PLANNING | IOZ & LEVEL III SITE PLAN REVIEW

MMC 2400-space employee garage (ground level + 8 tiers) w/ 52 adjoining surface parking spaces (replacing 283 spaces in 'First Atlantic Lot')

190 St. John Street

DUMPSTER ENCLOSURE & PAD DETAIL
SCALE: N.T.S.

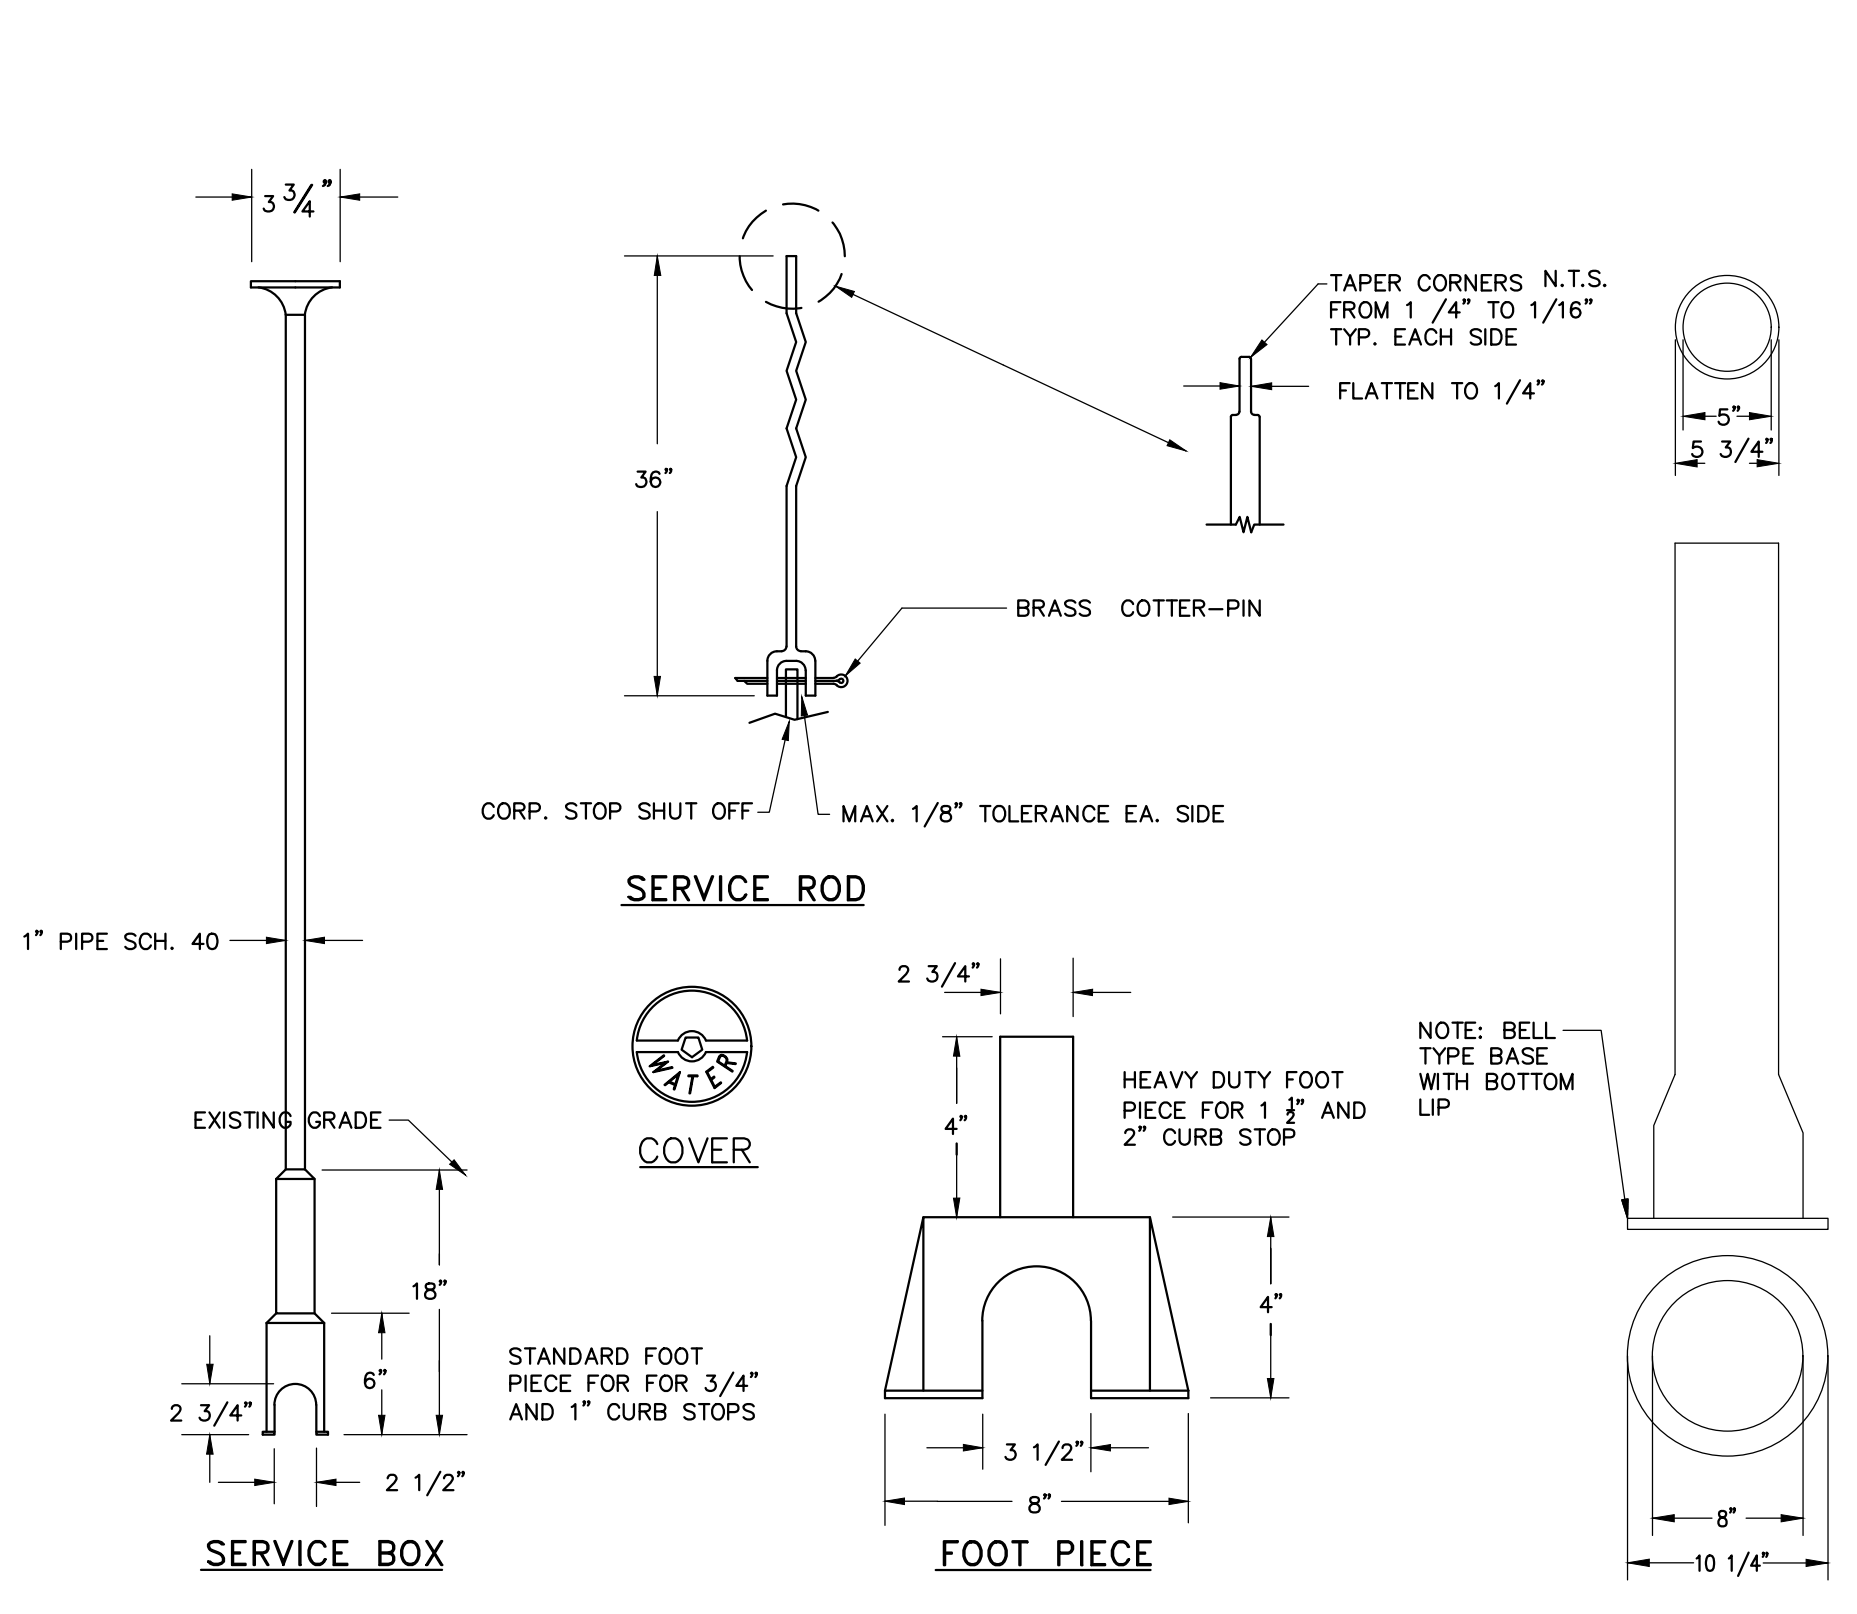
c. Availability and Adequate Capacity of Public Utilities	<ul style="list-style-type: none"> Need capacity to serve letters Revise dumpster enclosure to wood Provide capacity to serve letters upon receipt 	•
Site Design	a. Massing, Ventilation and Wind Impact	<ul style="list-style-type: none"> 	•

BIKE RACK DETAIL
N.T.S.

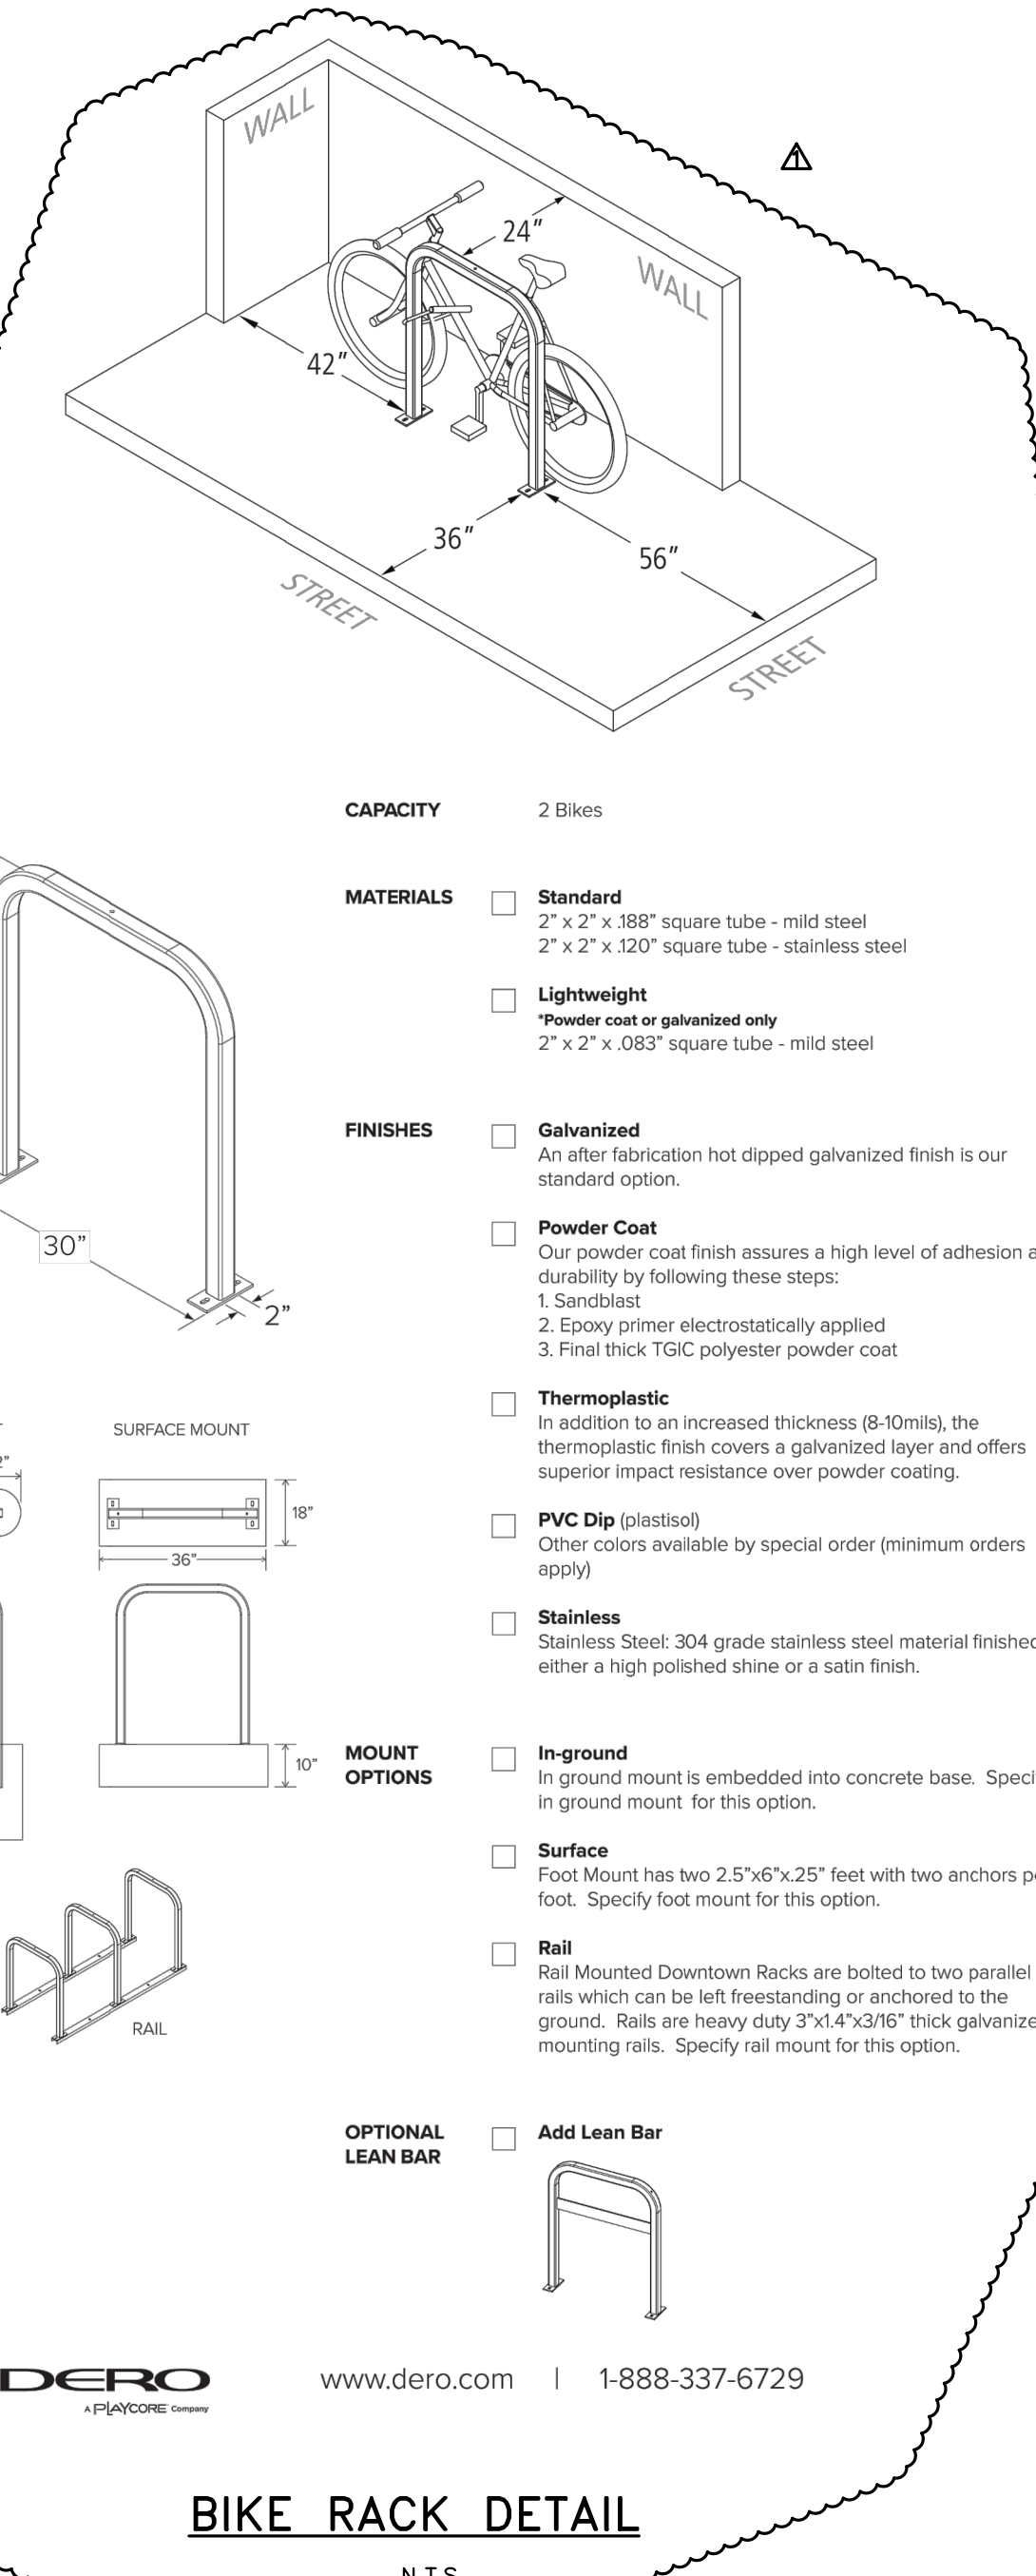
d. Parking	<ul style="list-style-type: none"> See notes on parking analysis above Support partial waiver on bike parking. However, bike parking location (in off-corners of ground level of garage) should be reevaluated. Is there a more accessible location closer to the entrances? 	•

ROOF DECK PARKING LIGHTING STATISTICS:

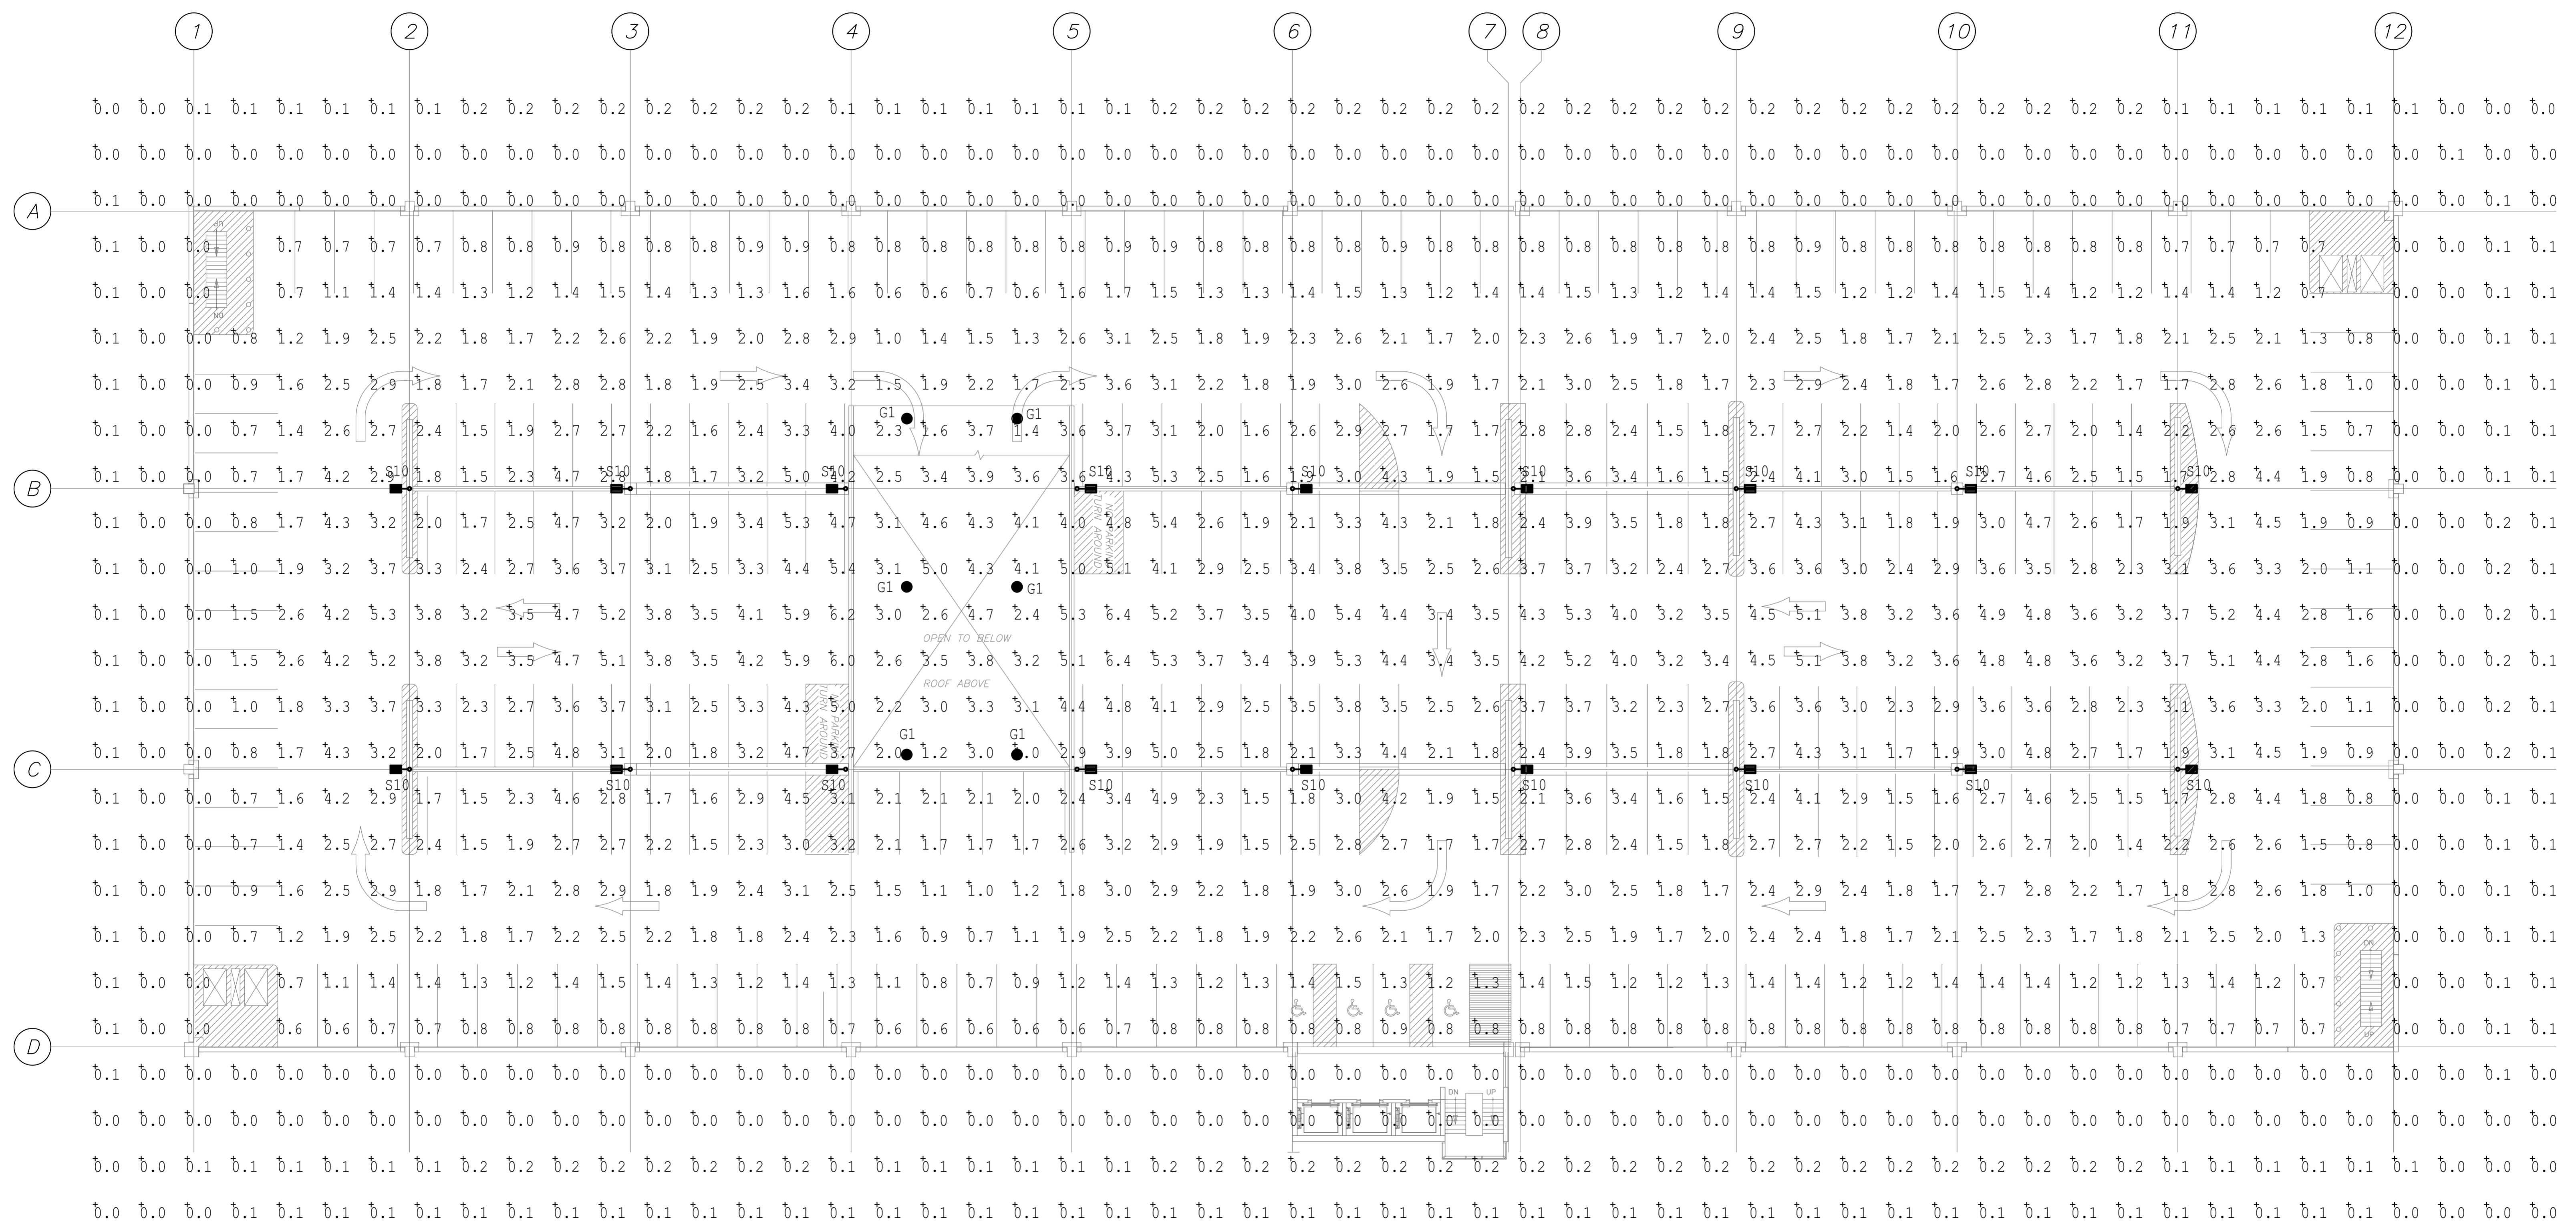
e. Historic Resources	<ul style="list-style-type: none"> 	
	f. Exterior Lighting	<ul style="list-style-type: none"> Need waiver request for average illumination levels Is there an opportunity to dim or turn off lights at night when use will be down? Concern re visibility of rooftop lights from Western Prom. Can the top deck be closed down at night and these lights be shutoff? As noted above, may need lighting within Western Prom. Further info on this pending evaluation noted above. 	•
